Willow PRVD

RE: Willow P.R.U.D., Mitton and Lassell Streets

On October 29, 1996 the Portland Planning Board voted unanimously (5-0; Krichels, Decourcey absent) on the following motions regarding the Willow P.R.U.D. subdivision and site plan:

**TO:** Sarah Hopkins, Senior Planner  
**FROM:** Steve Bushey, Development Review Coordinator   
**DATE:** October 21, 1996  
**RE:** Fore River Place Subdivision Review Letter #5

**Site Development Plan**  
**Fore River Place**  
Lassell & Milton Streets

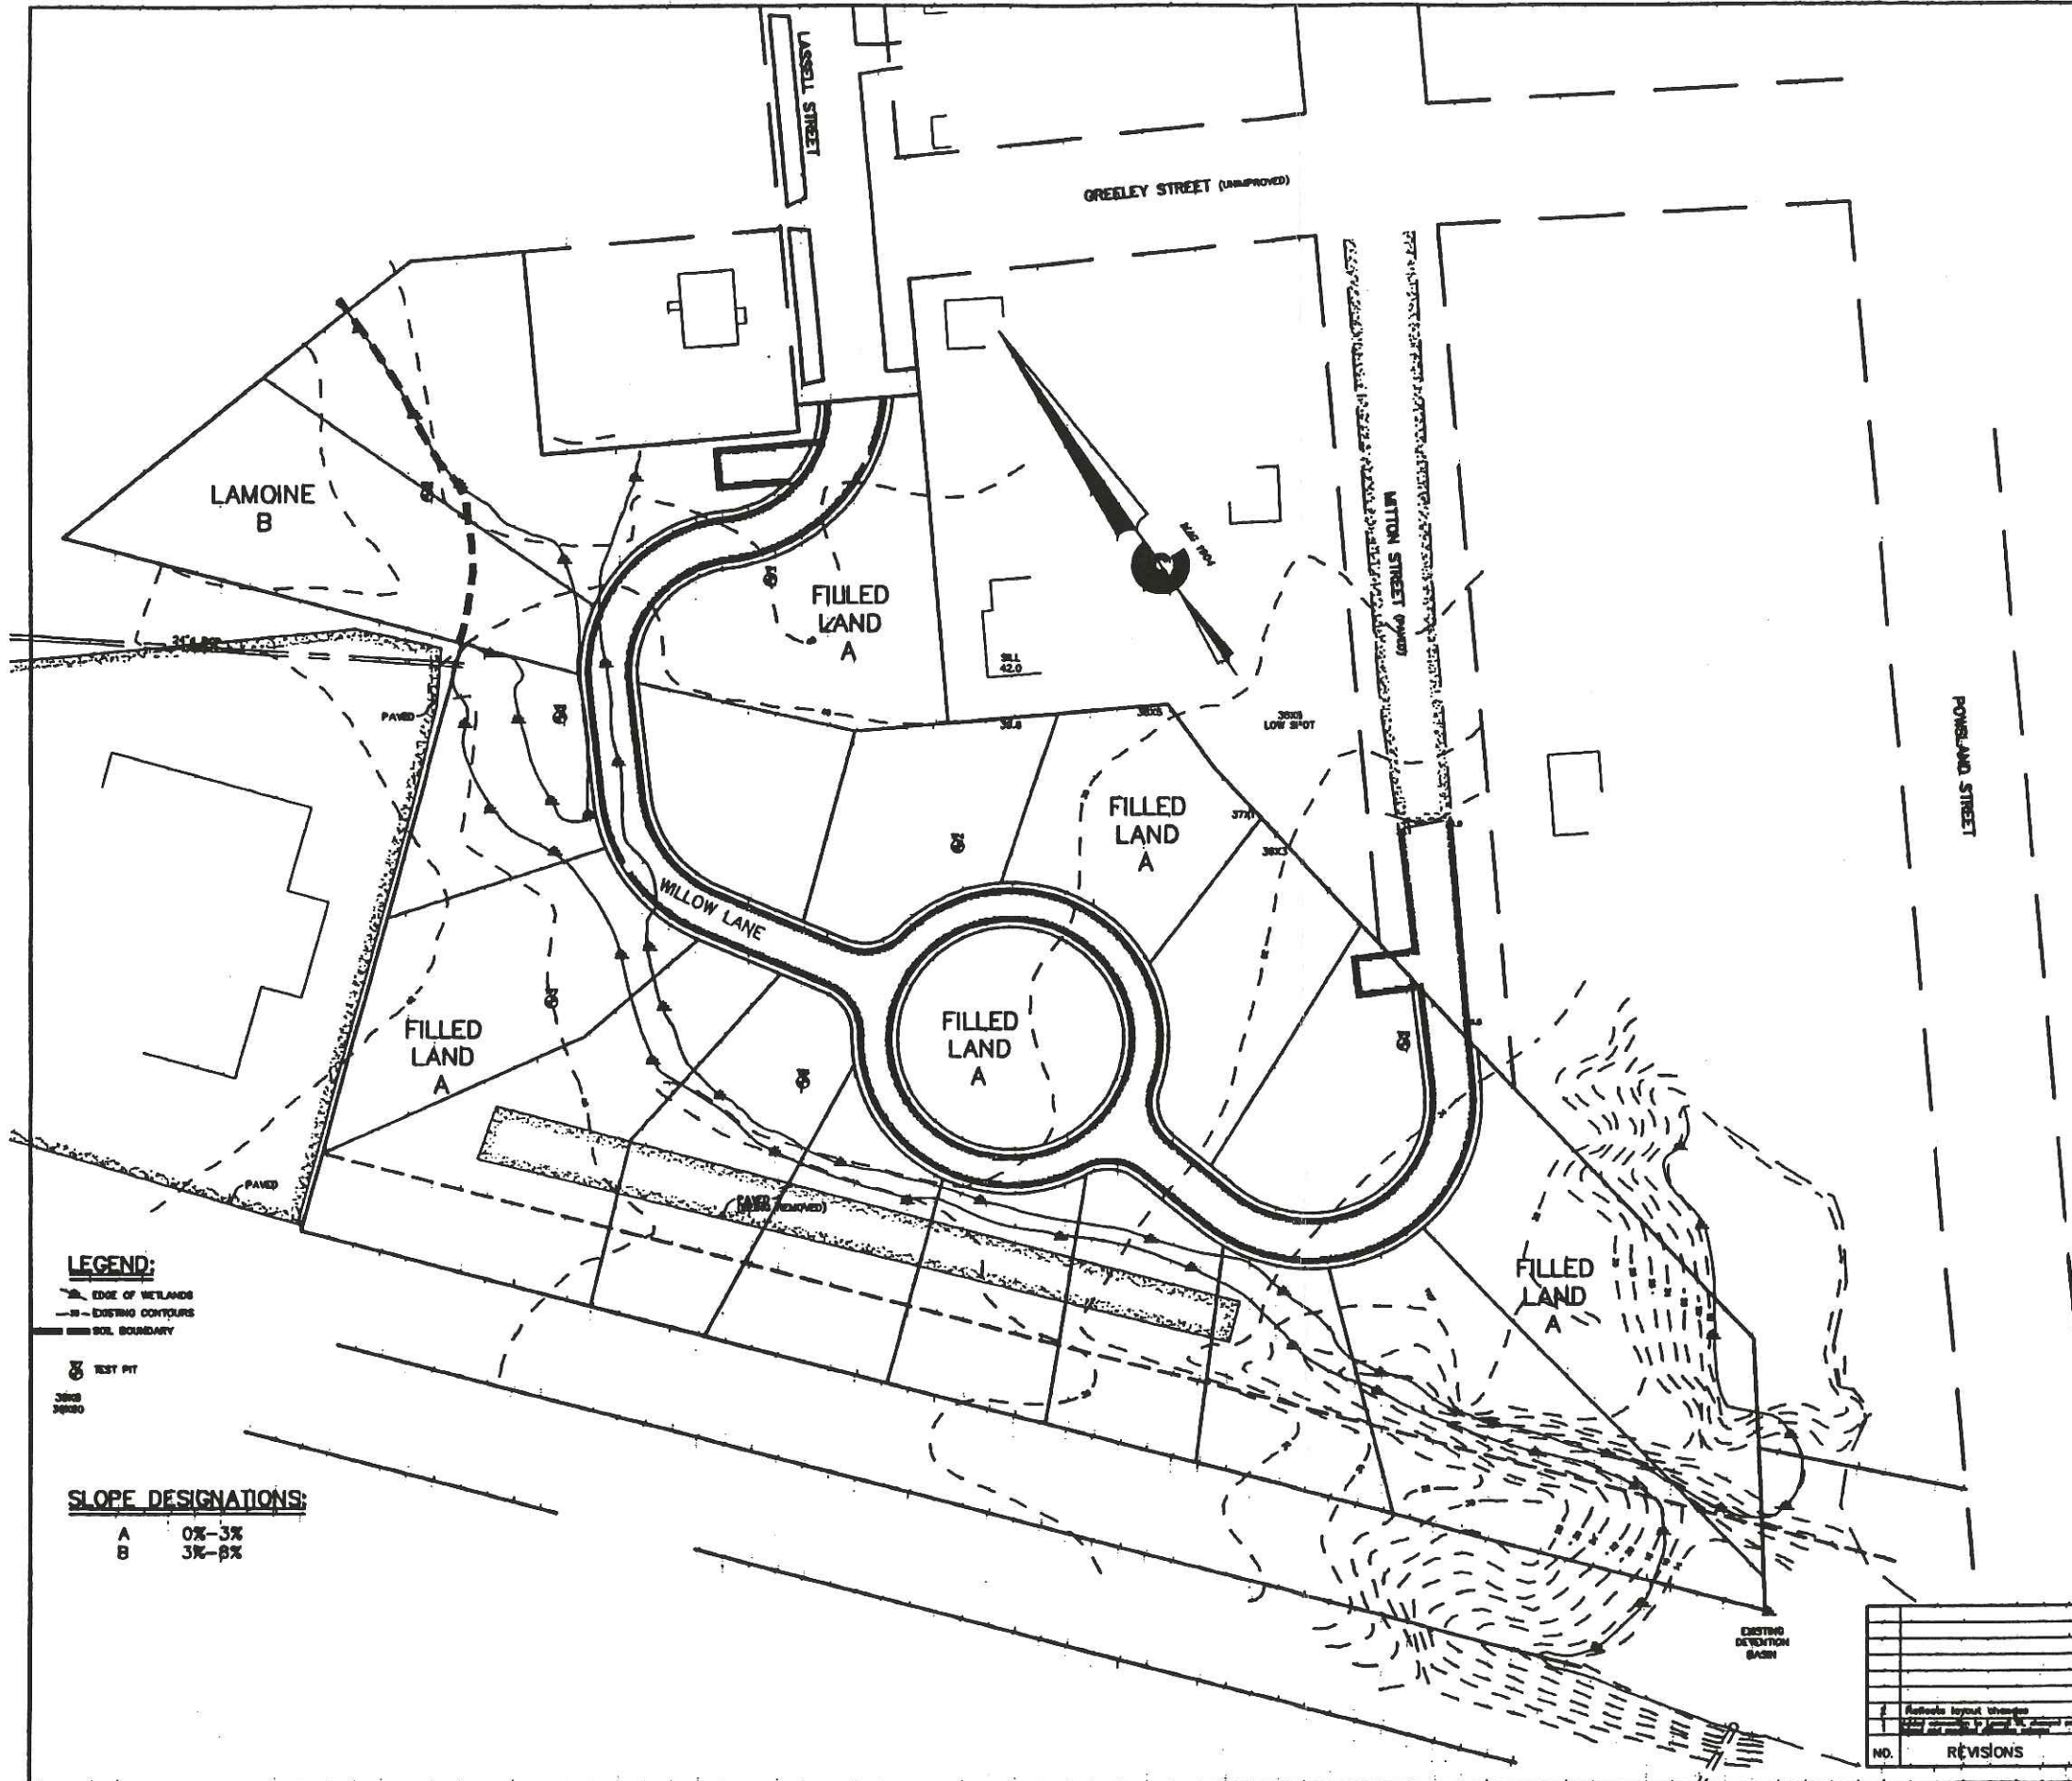
- 4. The applicant should provide dimensions for the proposed drainage easements and/or legal descriptions for the city's records.
- ok 5. The site development plan should be revised to include the note which was simply taped onto the review copy provided to me.

- ok 8. The lot #6 grading has not been completed along its frontage. Specifically, the elevation 40.0 contour has not been shifted to reflect the new road construction.

**Profiles & Construction Details**  
**Fore River Place**  
Lassell & Milton Streets

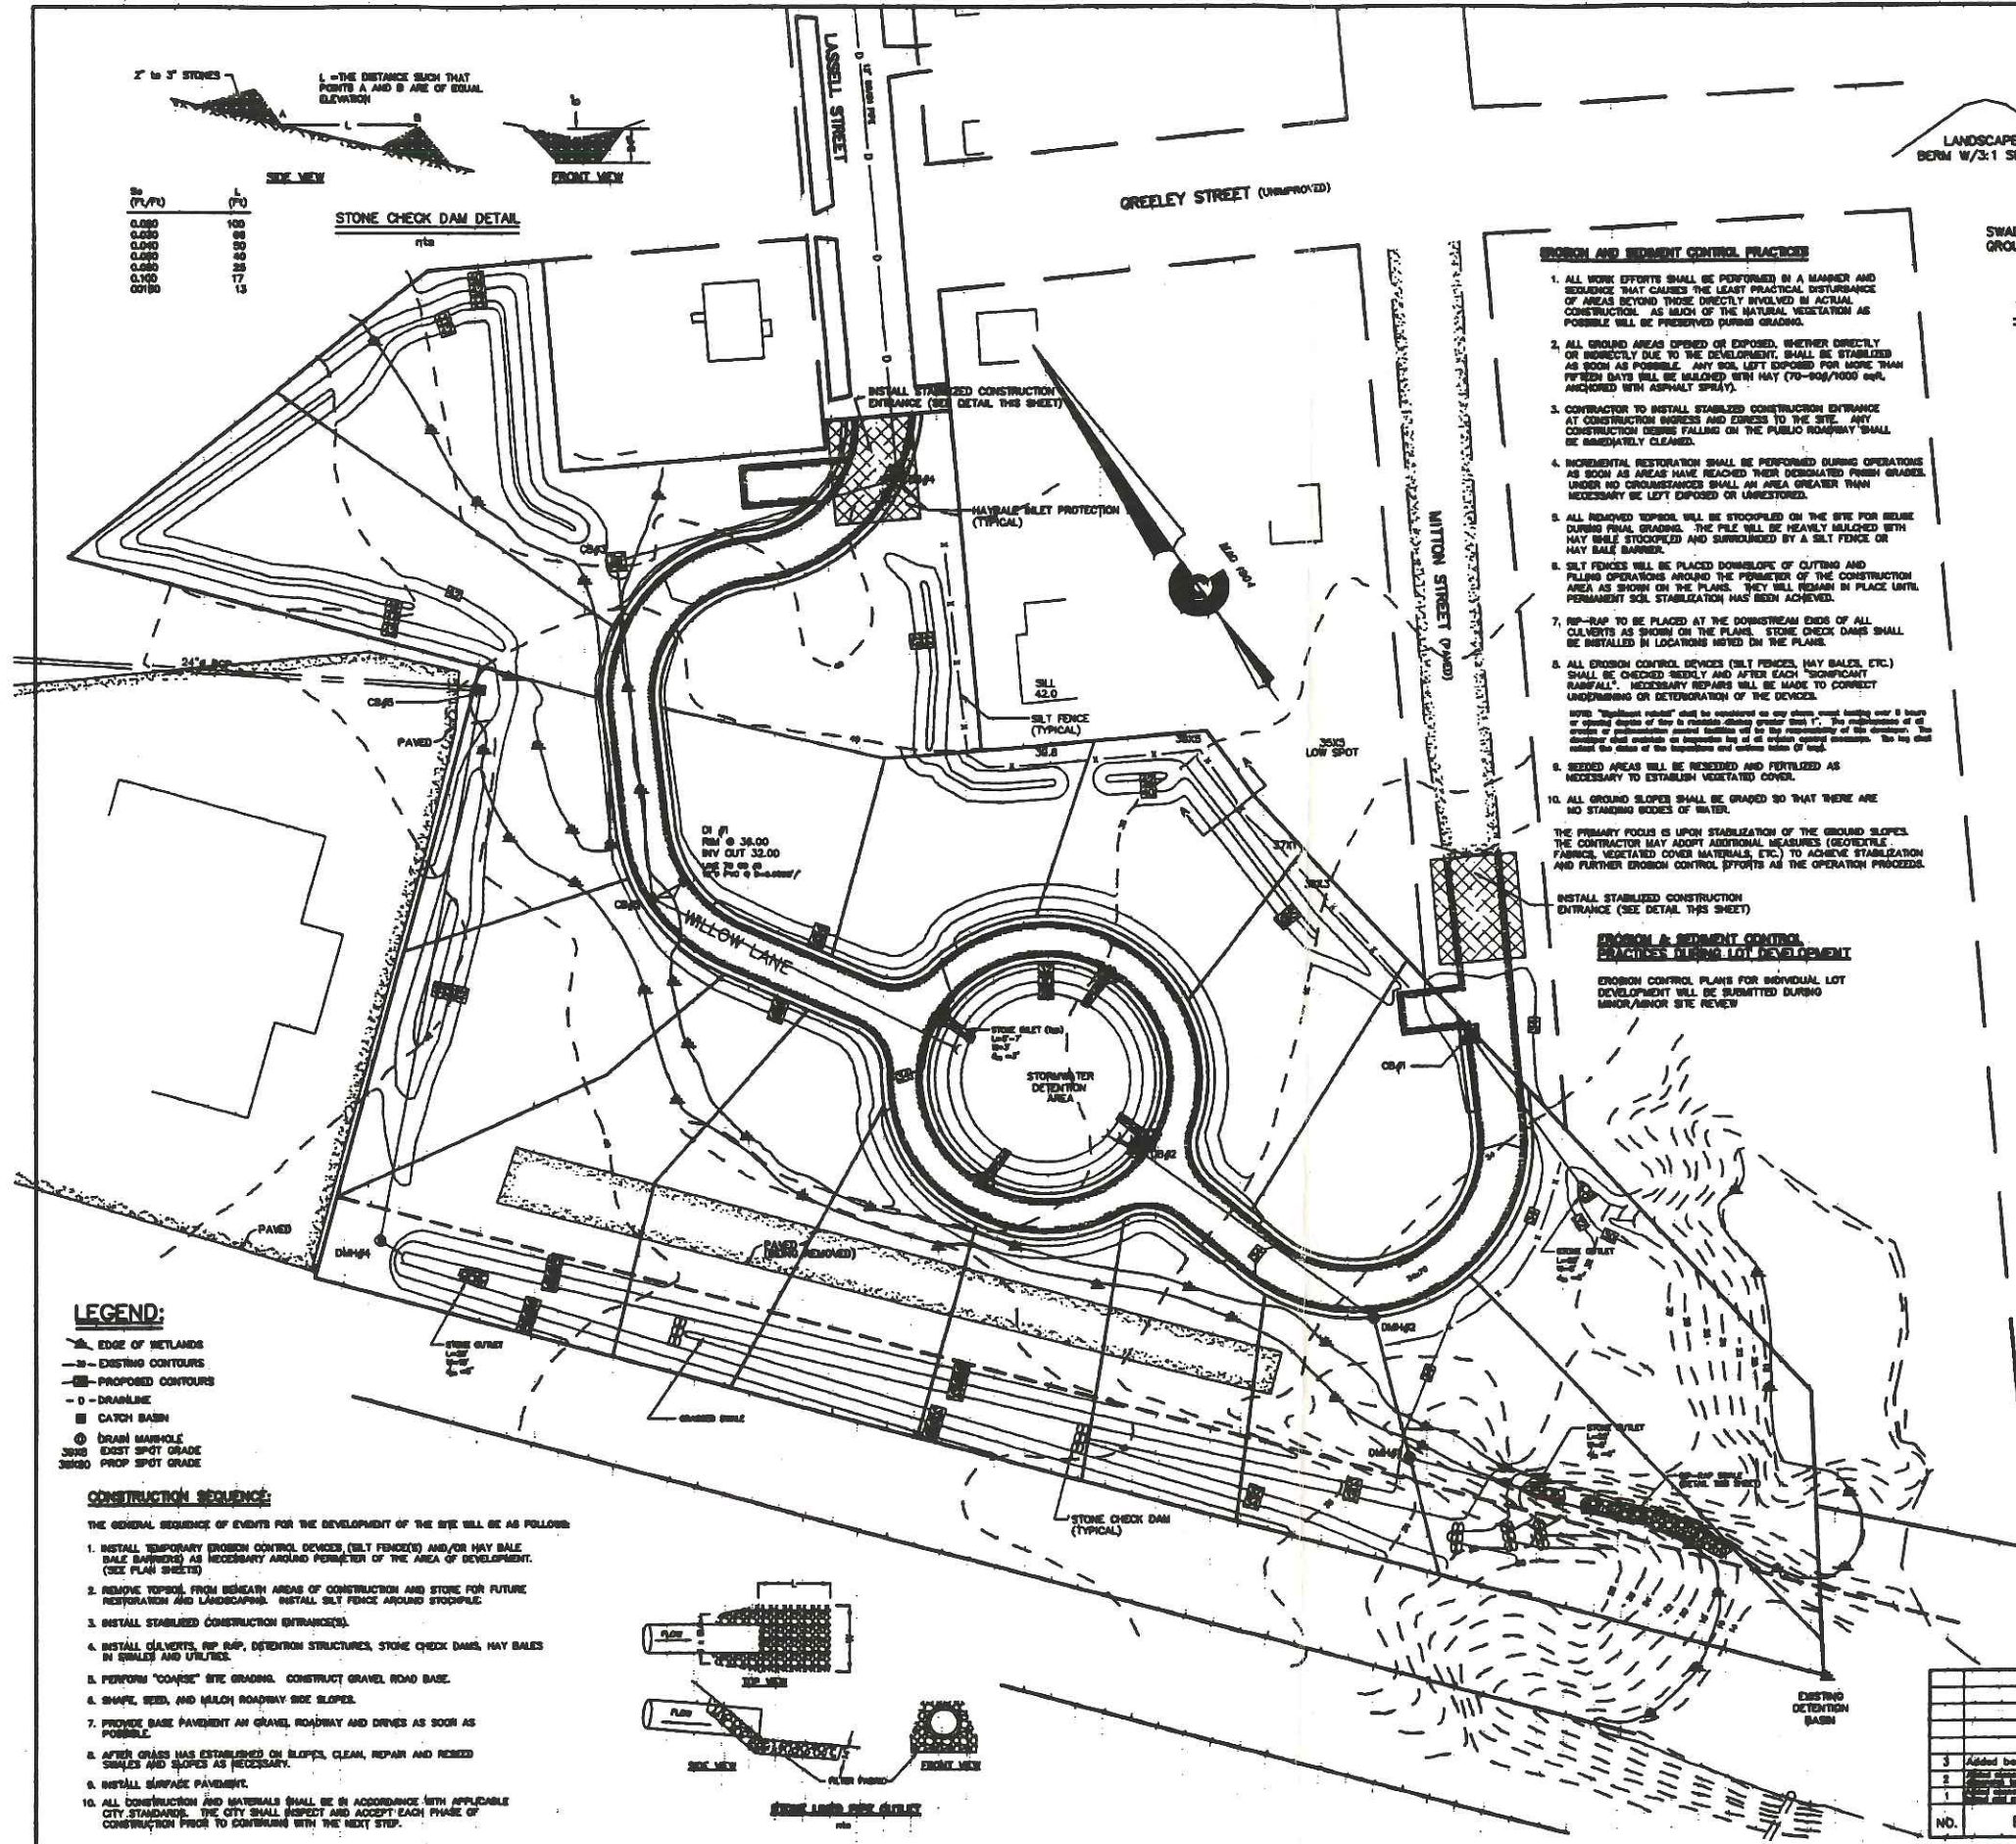
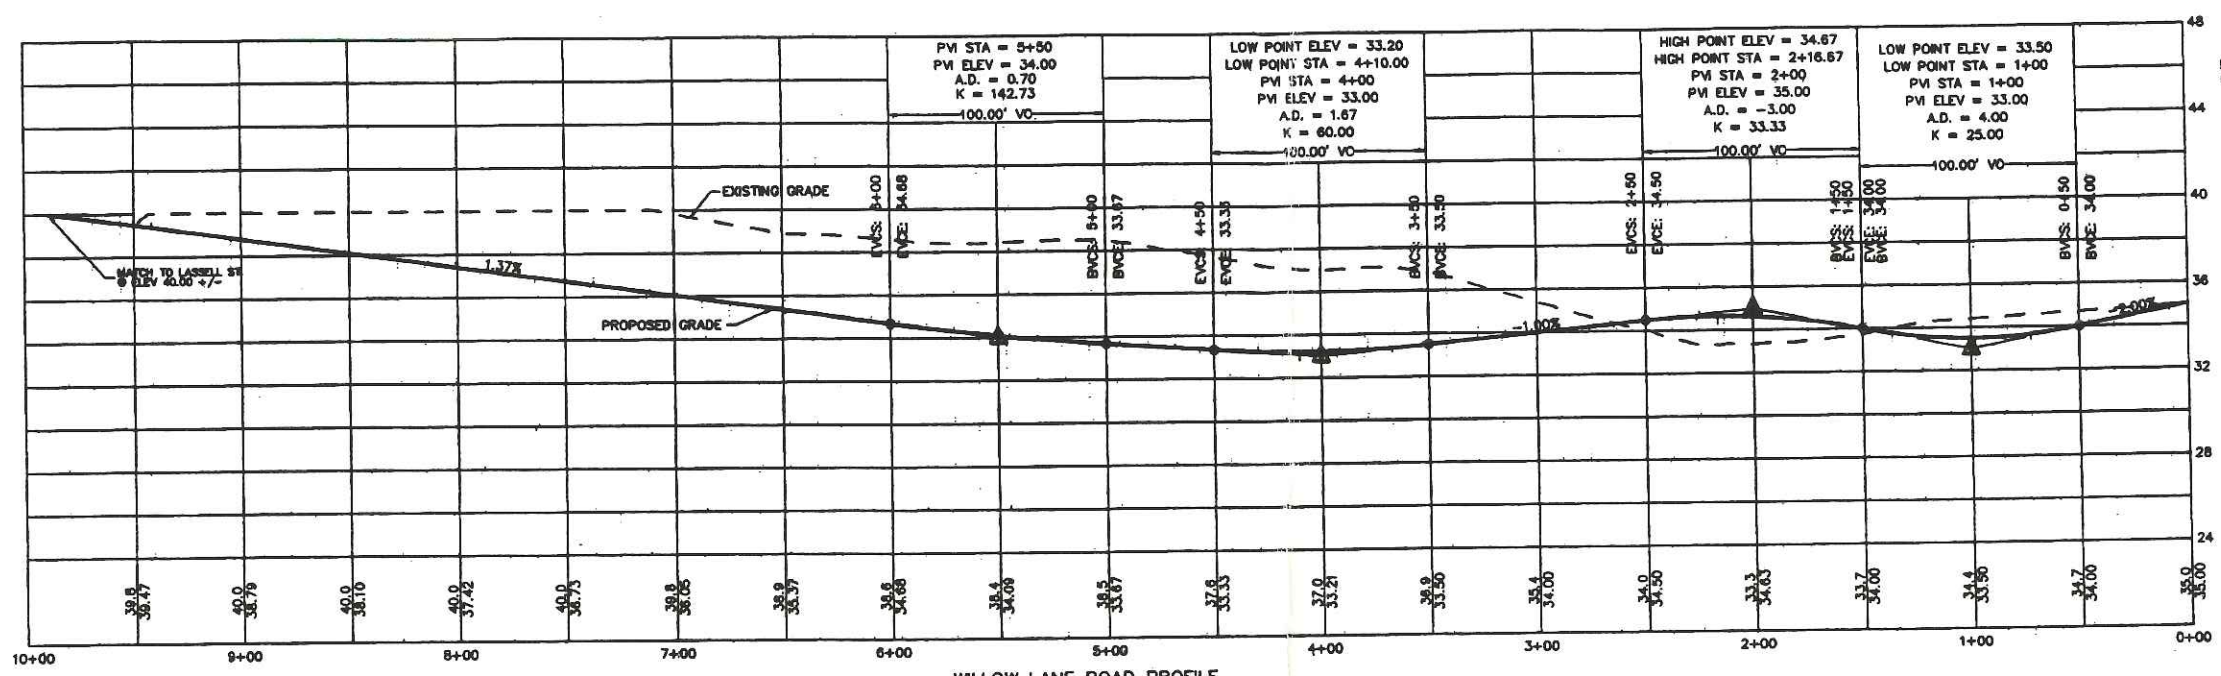
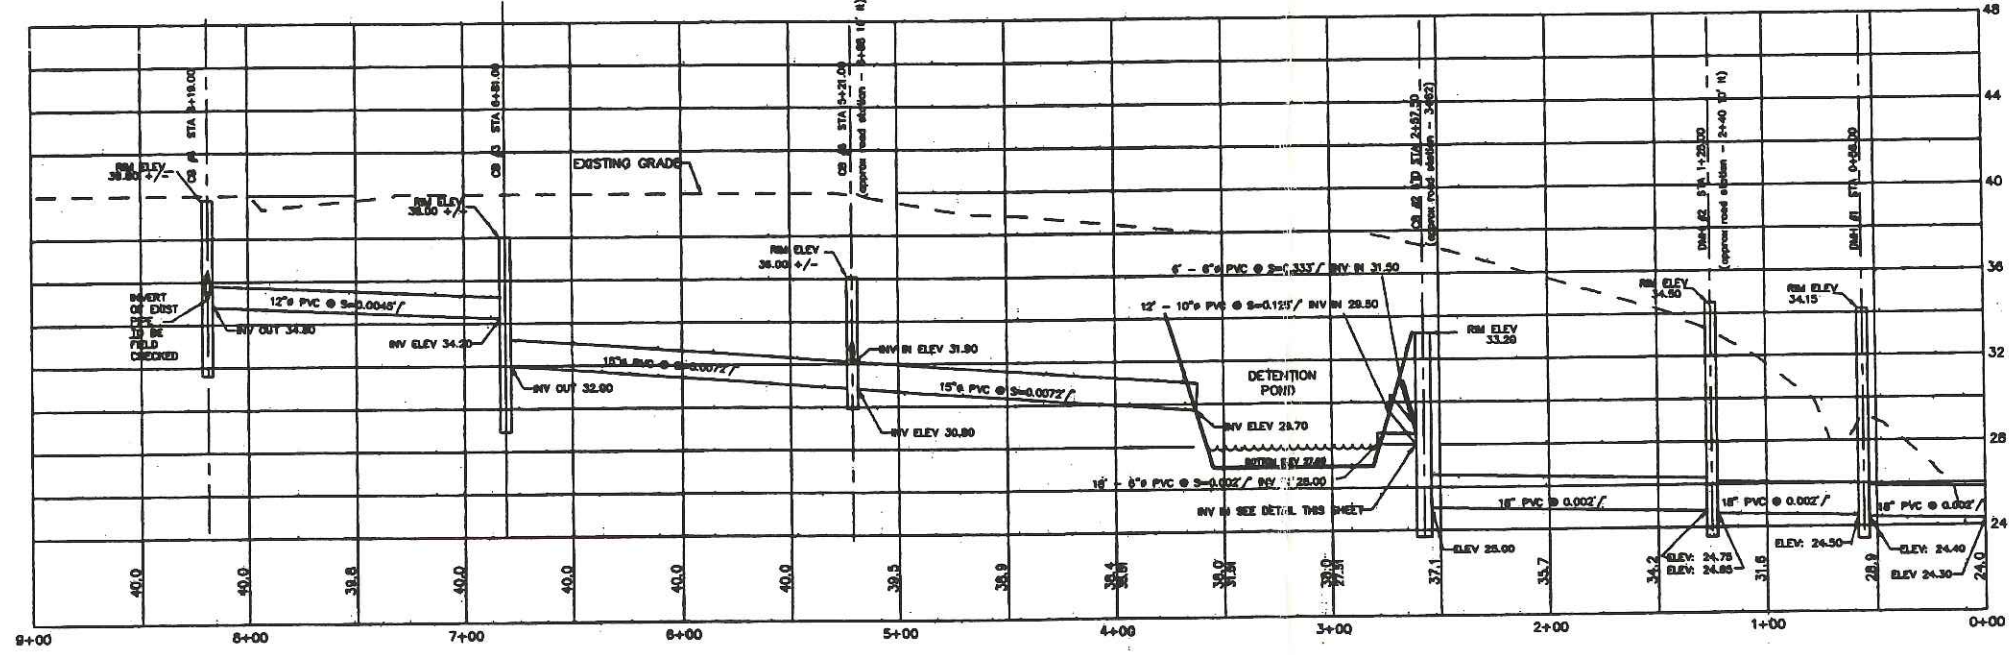
1. That the plan was in conformance with the Subdivision Review Ordinance of the City Land Use Code with the following conditions:
  - ok i. That the roadway profile be revised to include 2" hot bituminous pavement (Grade B) and 1 1/2" hot bituminous pavement (Grade C) for the two final pavement layers of the Willow roadway.
